July 13, 2017

**RE: T-Mobile on 4th St
Grading Plan
Engineers Stamp Date: 6/28/17
Hydrology File: F14D075**

Based on the information provided in your submittal received on 6/28/17, the Grading Plan is not approved for Building Permit. The following comments must be addressed prior to approval:

C-101

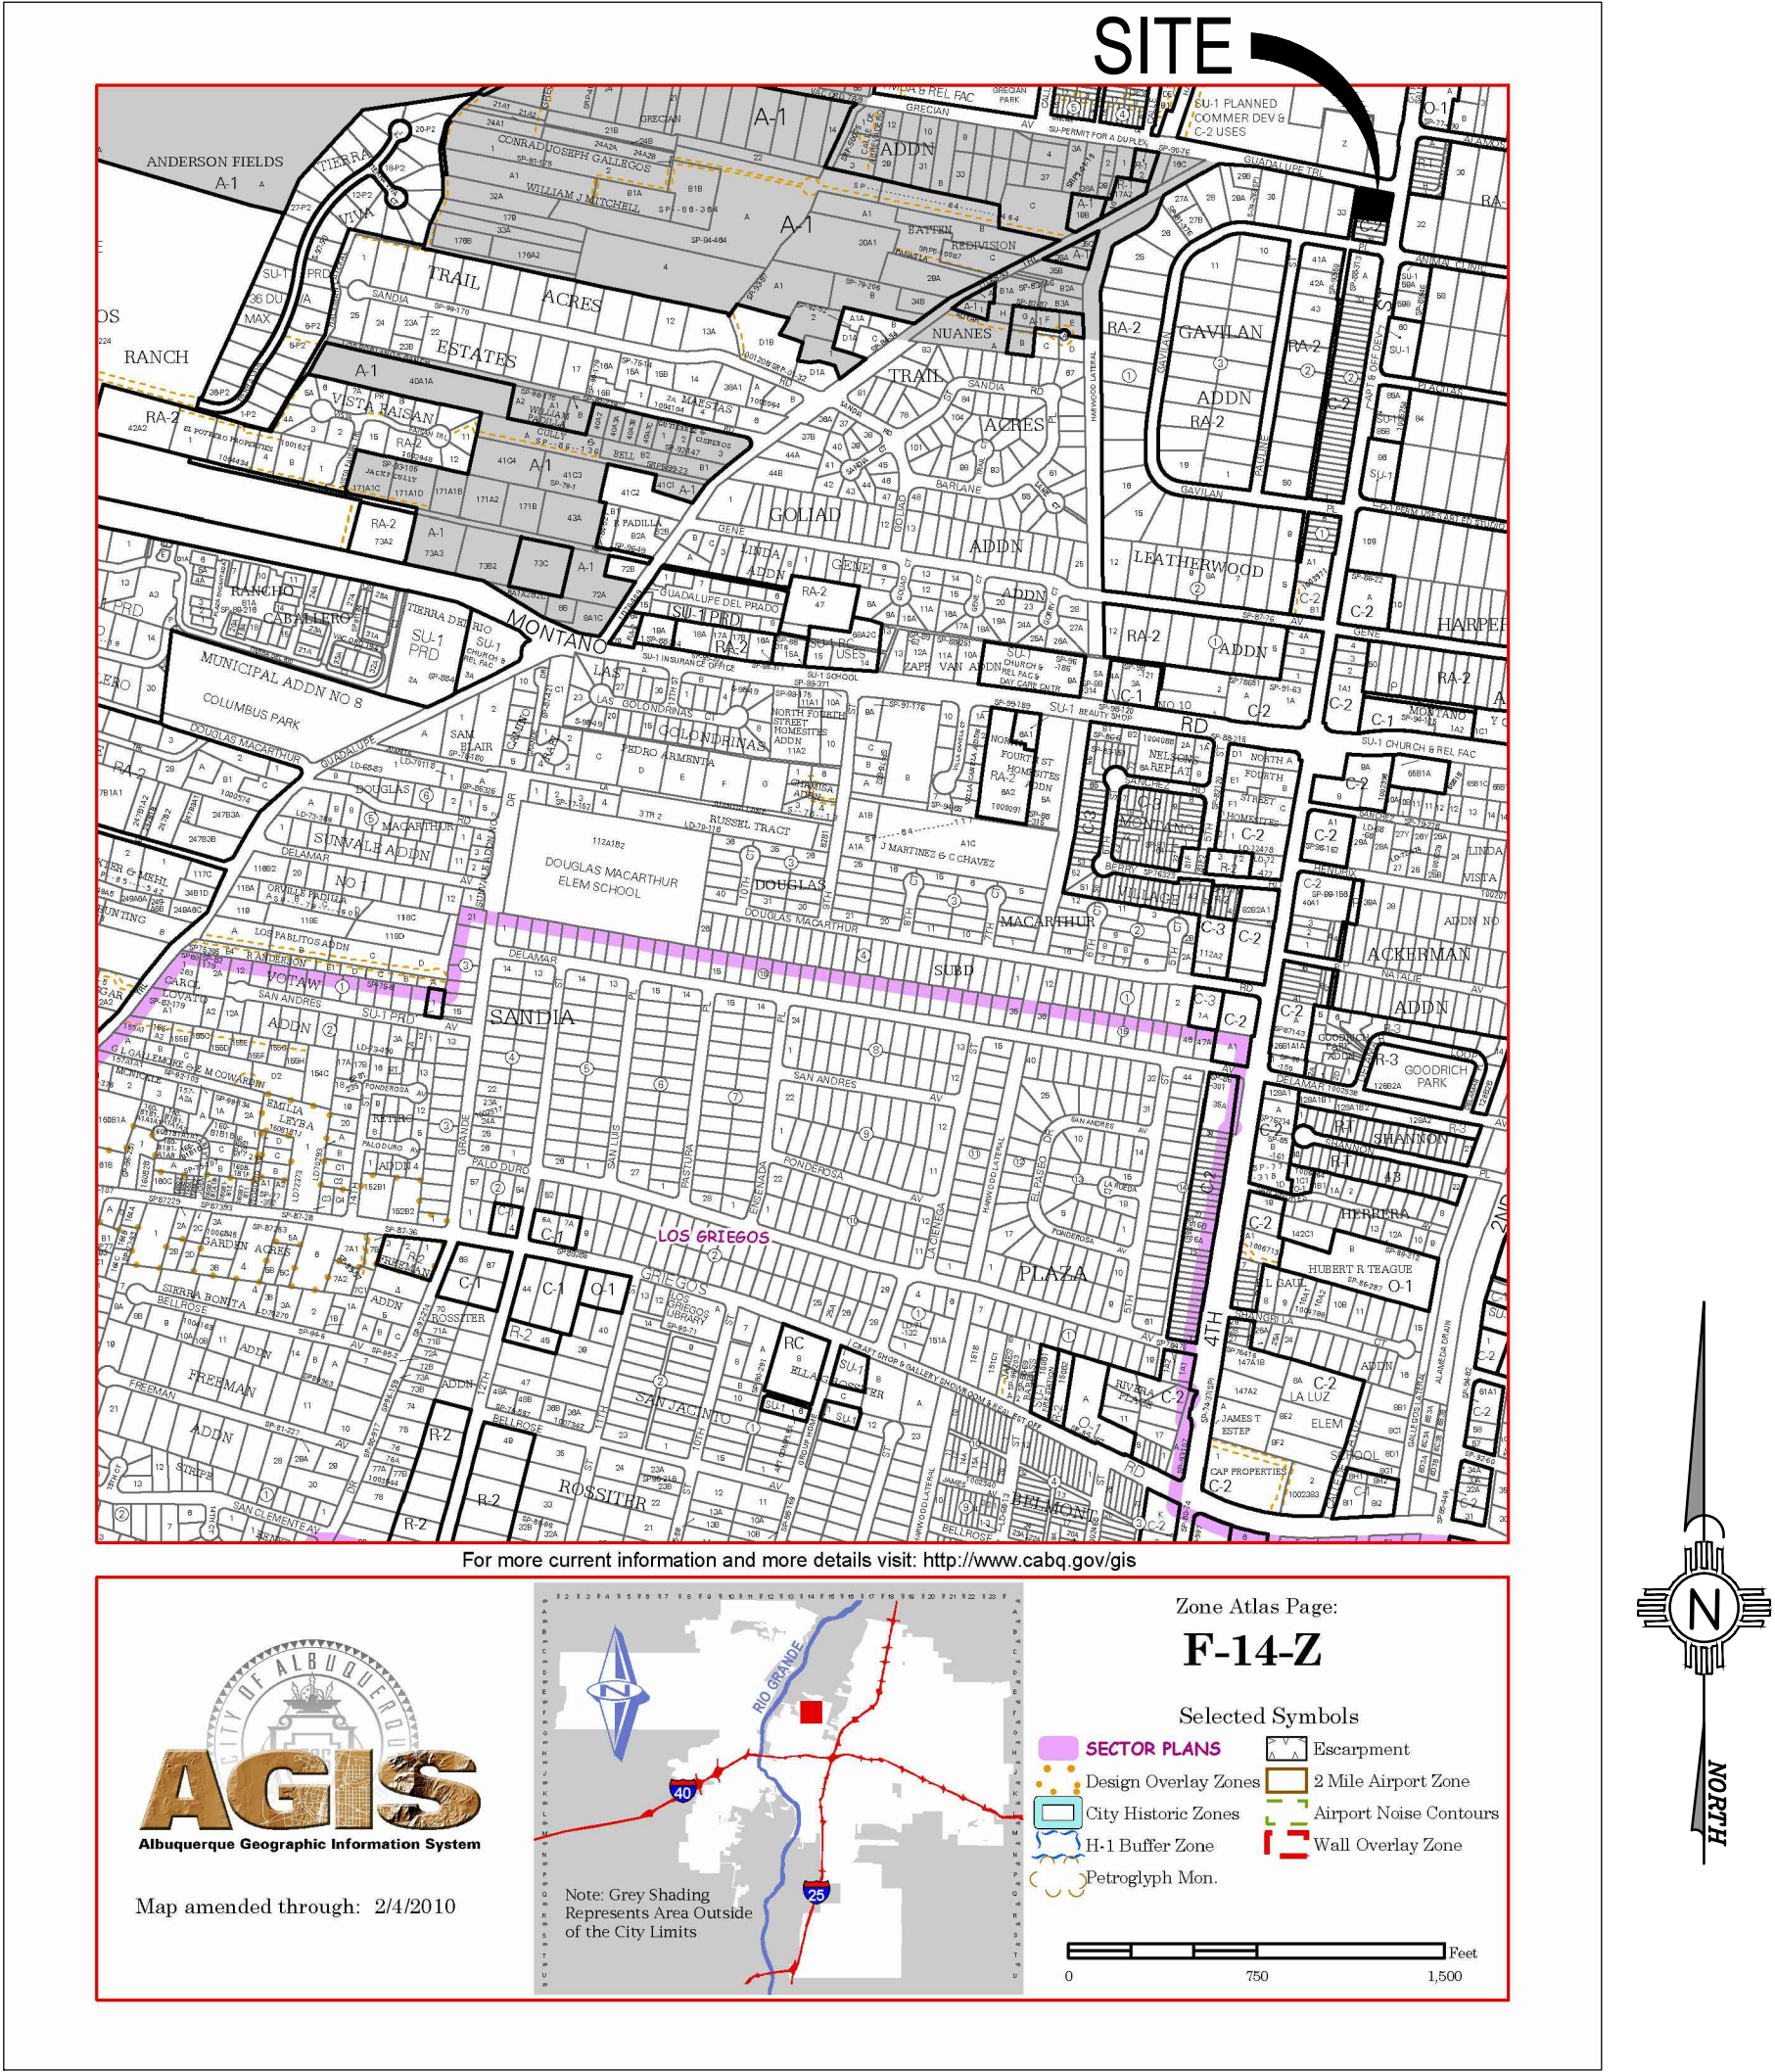
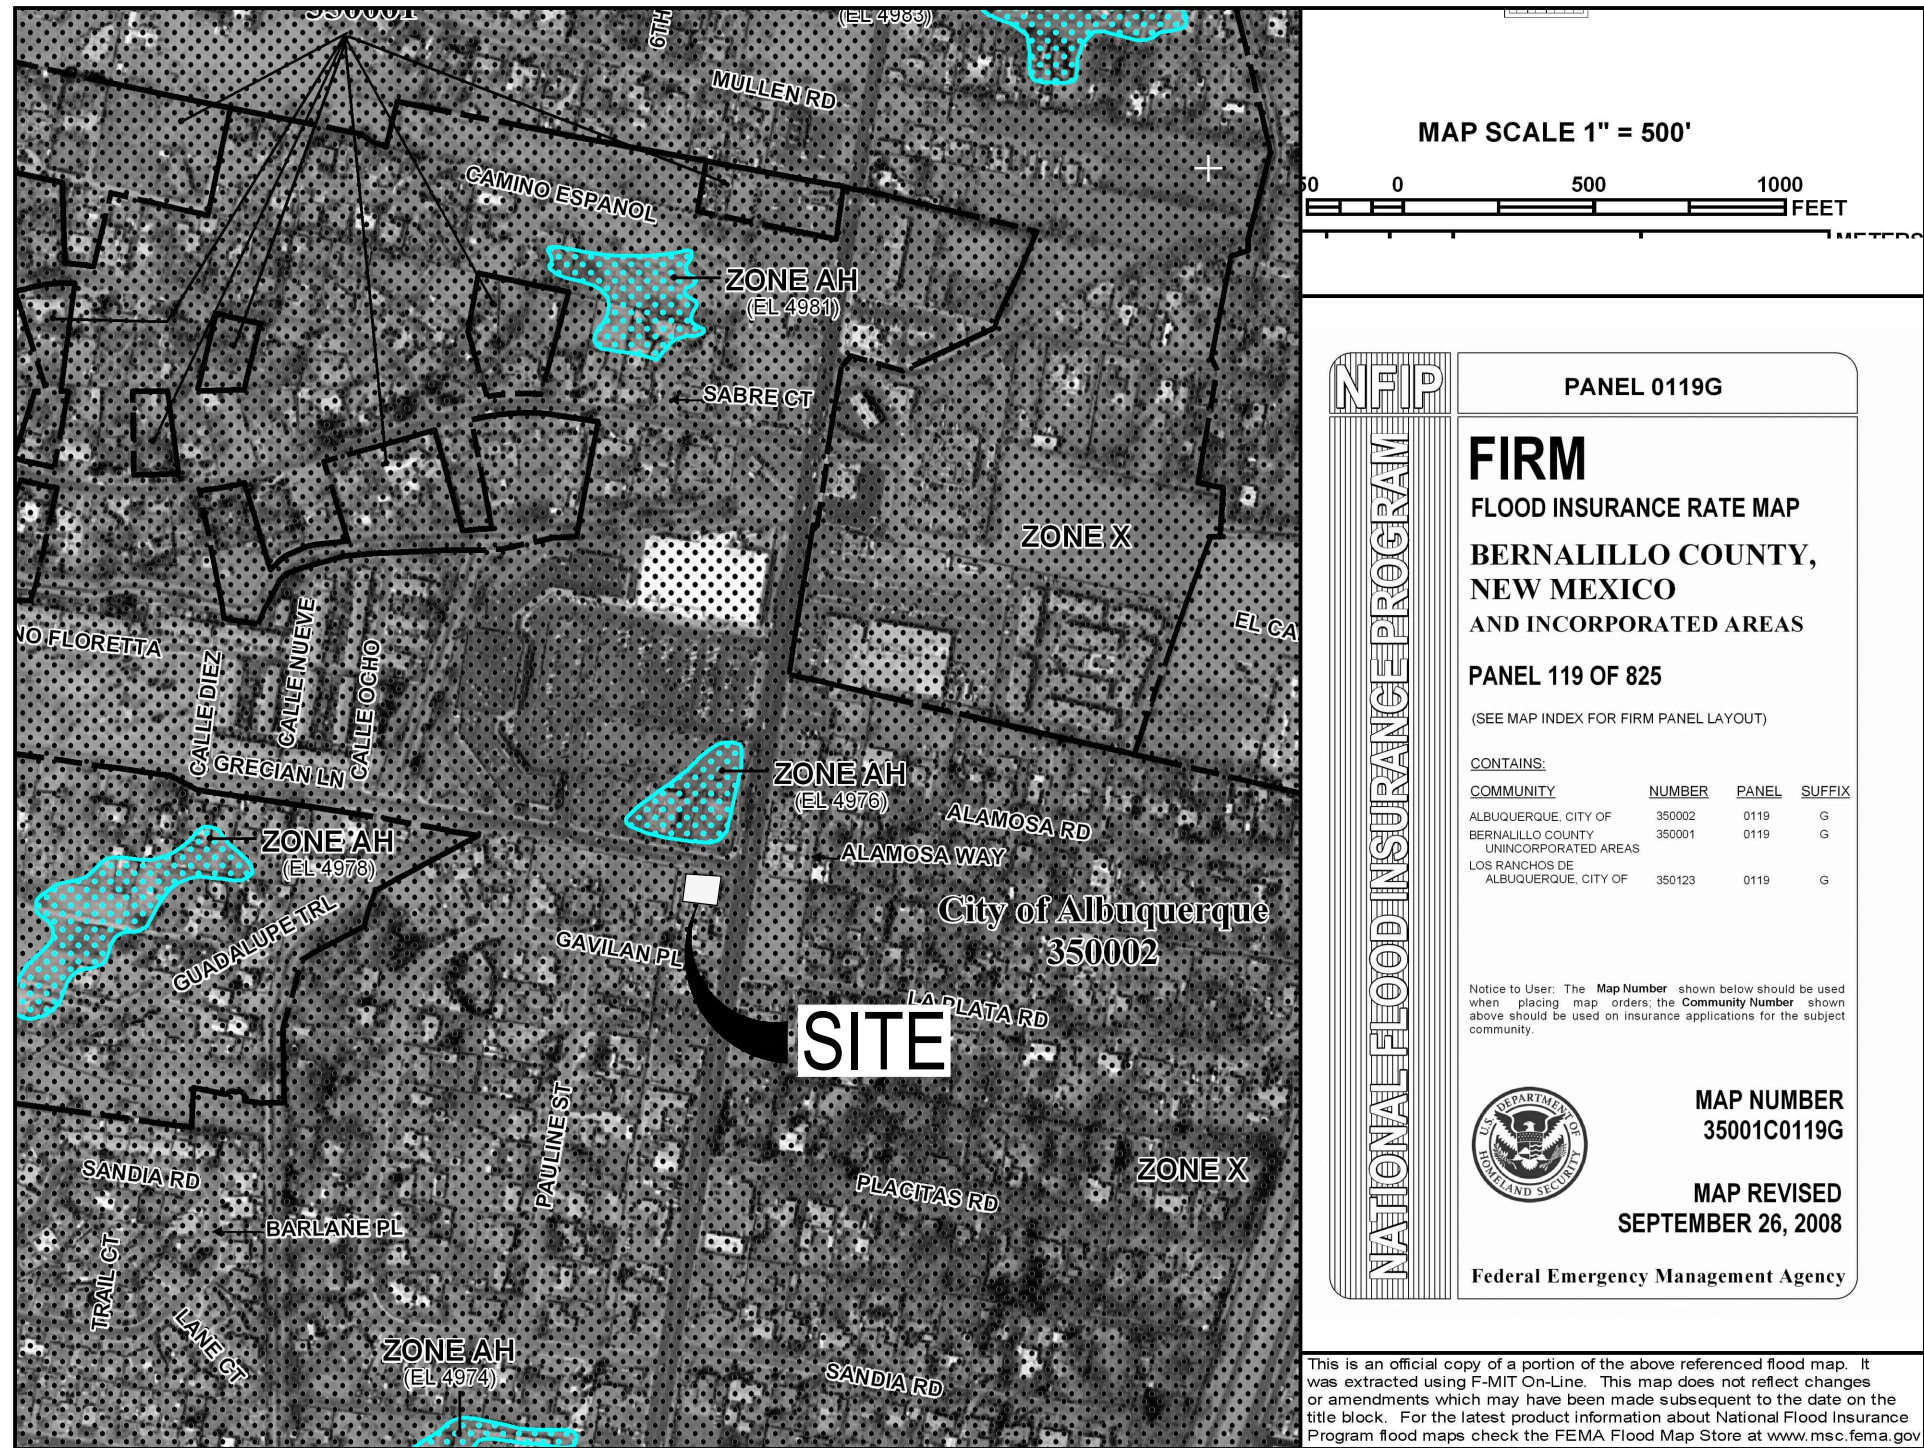
3. The site must demonstrate adequate downstream capacity per § 14-5-2-12 (10)(G) of the Albuquerque Code of Ordinances.
4. If downstream capacity does not exist, on-site retention must be provided.

5. Provide waterblocks, at least 0.67' high, at the entrance off 4th St to prevent flows from entering your site.
6. Elevate the finished floor at least 1' above adjacent grades; the highest adjacent grades appear to be along 4th street and at the drive entrance.

7. The low point in the parking lot appears to be at 77.26, in the NW corner; provide a curb cut here into the pond to prevent ponding in the parking lot.
